North Littlehampton: Fitzalan Link Crib Sheet

Job number:	A088461
Project name:	North Littlehampton: Fitzalan Link
Application number:	LU/234/16/REM
Name of document:	Crib Sheet
Date:	28 November 2016
To:	Tim Townsend, West Sussex County Council
From:	WYG – Louise Ball
CC:	Laura Graham – Persimmon Homes
Subject:	Landscape Design
File reference:	A088461 Fitzalan link – response to WSCC comments on submitted documentation; Comments from ADC Planning Officer (Hilary Kernohan) and ADC Greenspace

Comments below relate to an e-mail sent by Tim Townsend (Senior Planner, West Sussex County Council), dated 10.11.16.

FL.1

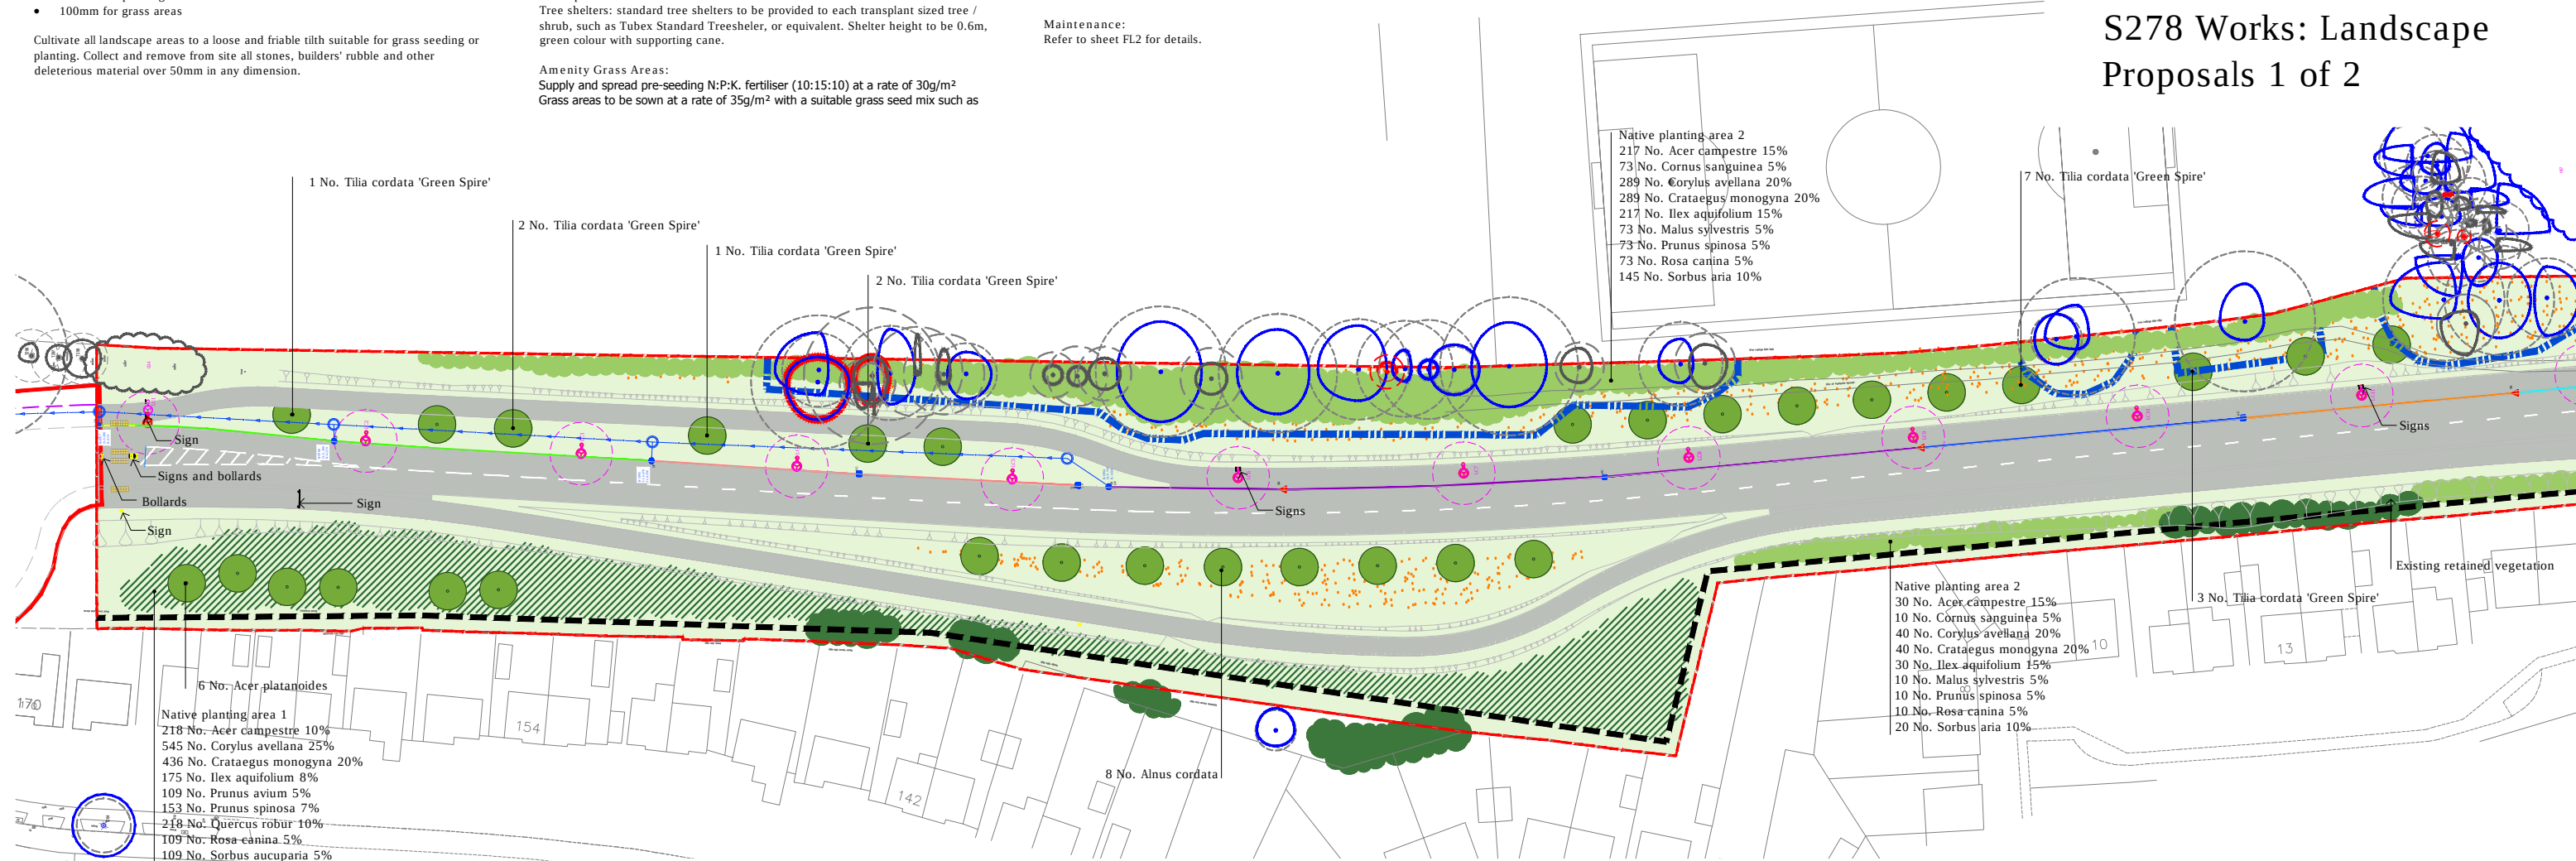
4 WYG draft sketch 2	Proposed planting in SE of the proposed roundabout has now been omitted and correct surface finish shown.
5 WYG draft sketch 1	Details of plant implementation has been provided in the Outline Specification shown on drawing FL1. This includes details of 'notch planting'.
6 The detailed specification	A plant matrix has not been included as a description of how the plants are to be arranged is provided in the 'Outline Specification' on application drawing FL2 (ref A088461 FL2 Landscape Proposals 2 of 2).
7 Species	- Elder has now been removed from the mixes. - Whitebeam has now been included in the mixes. - Italian alder, Norway maple and Whitebeam have now been included as part of the avenue tree planting proposals.
8 Trees identified for removal	The site clearance drawings are consistent with the arboriculture report / landscape drawings.

Ref	Comments
19 Protection measures	- Protection measures for new plant establishment has been included in the outline specification on drawing A088461 FL1. This will be standard tree/shrub shelters and will be provided around each transplant sized tree/shrub. - Maintenance and management information has now been provided on drawing A088461 FL2 to ensure that the plants establish, thrive and develop. - Long term maintenance information has been provided.

FL.2

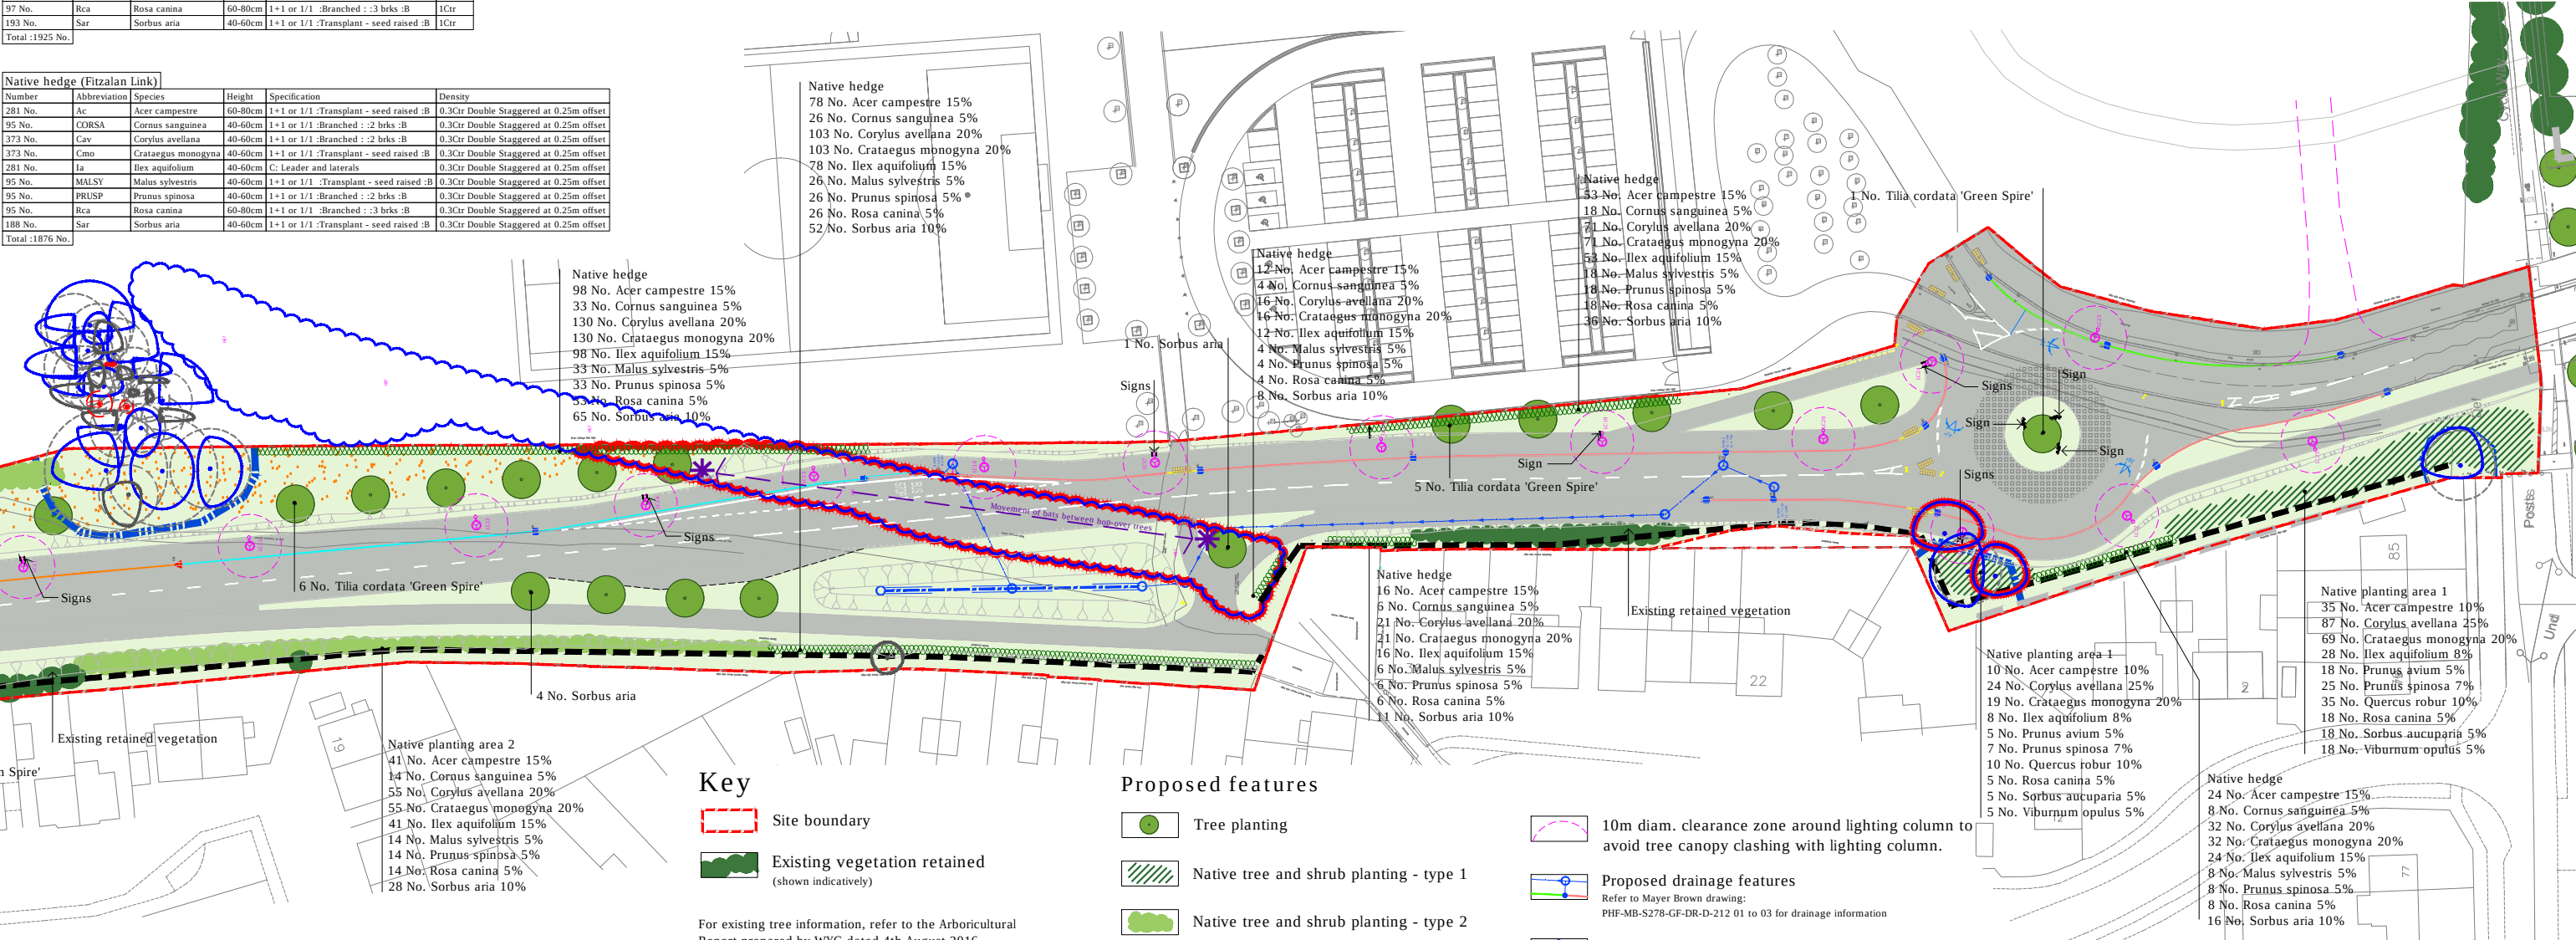
14 Width of landscaping	Planting has been included along the acoustic fence where possible. Restrictions in some locations is due to the site boundary constraints.
15 Native planting	- This is a mix of native trees and shrubs to be planted. - The trees and shrubs will be planted as transplants, with 1m spacing between the plants. - Specifications for the proposed trees and shrubs are included on drawing FL2.
